From: Allen, Tim
Sent: 30 January 2024 19:55
To: 'CottamSolarProject@planninginspectorate.gov.uk'
Cc: Midlands ePlanning
Subject: Cottam Solar Project Historic England response ExA 2nd Questions Individual ref 20037186 Our ref PL00763242

Cottam Solar Project Historic England response ExA 2nd Questions.

Individual ref 20037186
Our ref PL00763242

Arrows indicate former field boundary referred to in our written representation.

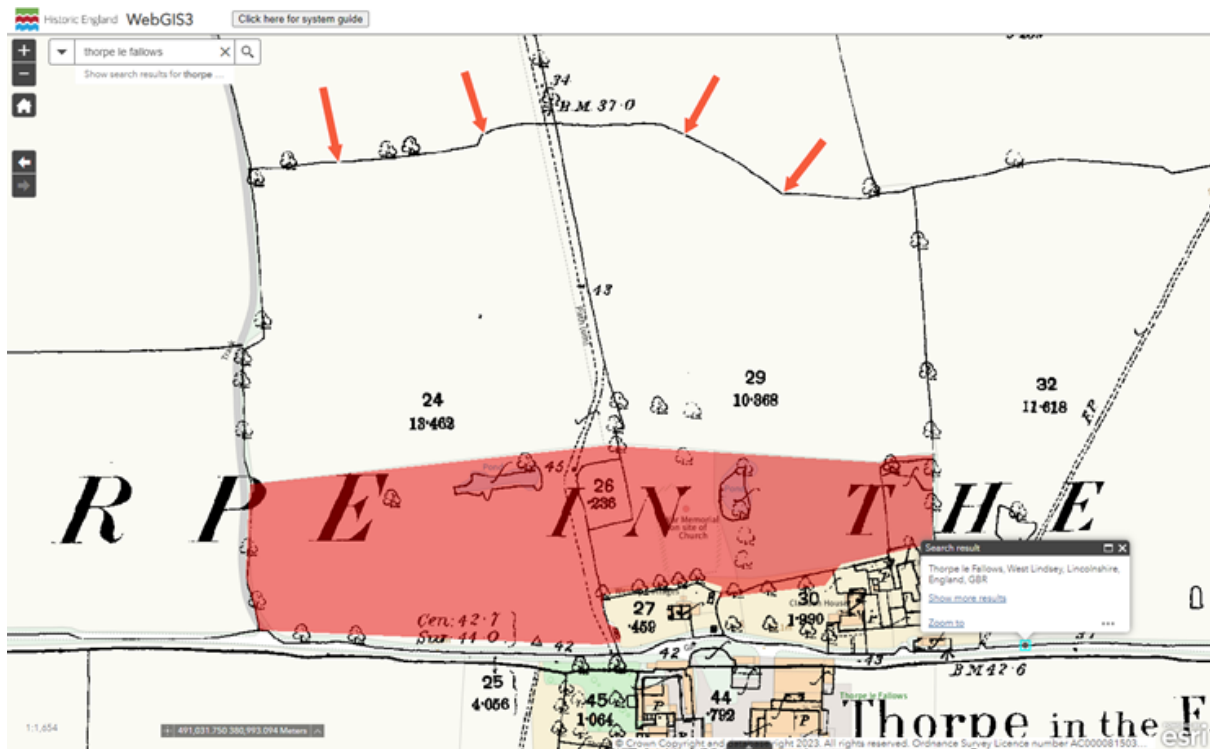
This former boundary has a direct historic landscape relationship to the shrunken settlement remains to its south and the rising round upon which Thorpe le Fallows sits. The irregular line of this east-west boundary as shown on the 1st edition OS 1:2500 mapping suggests it sat in an organic relationship to the pattern of open-field cultivation strips and associated land tenure, in contrast to the straighter more regular subdivision of strips characteristic of more structured enclosure.

- iii) how the solar arrays would relate to the former historic east-west boundary and whether the proposed boundary treatment has a bearing in this regard as mitigation. These were matters that were raised by the ExA at ISH2 where it concerned the historic environment.

We have set out a reasonable measure to conserve and better reveal the significance of the scheduled monument, and reframe it in the context of the harm resulting from development's transformation of its agrarian setting. The reinstatement of this former boundary as a limit to the solar array is both proportionate and necessary to a sustainable planning outcome. The irregular character of the boundary is important to the effectiveness of this mitigation, any functional straight-line security fencing would need therefore to sit north of the reinstated boundary. To be effective as mitigation the reinstated boundary would need to be a laid hedgerow and would benefit from the inclusion of some standard trees for instance crab apple, field maple etc.

Historic England envisages that the historic boundary would be reinstated on or about its former line derived from the first edition ordnance survey 1:2500 scale mapping. The historic mapping does not indicate the physical form of the boundary but the slightly irregular line and character of extant boundaries in the area would suggest a hedge and bank. The reinstatement of the former boundary would put the array in a separate space from the immediate environs in which the monument is appreciated and understood, its immediate context would be agrarian rather than solar. Whilst the array would likely still be visible from the monument the reinstated (hedge boundary) would provide some screening of the security fencing and the panels themselves. We assume the panels would start once they were clear of the shadow from the new hedge.
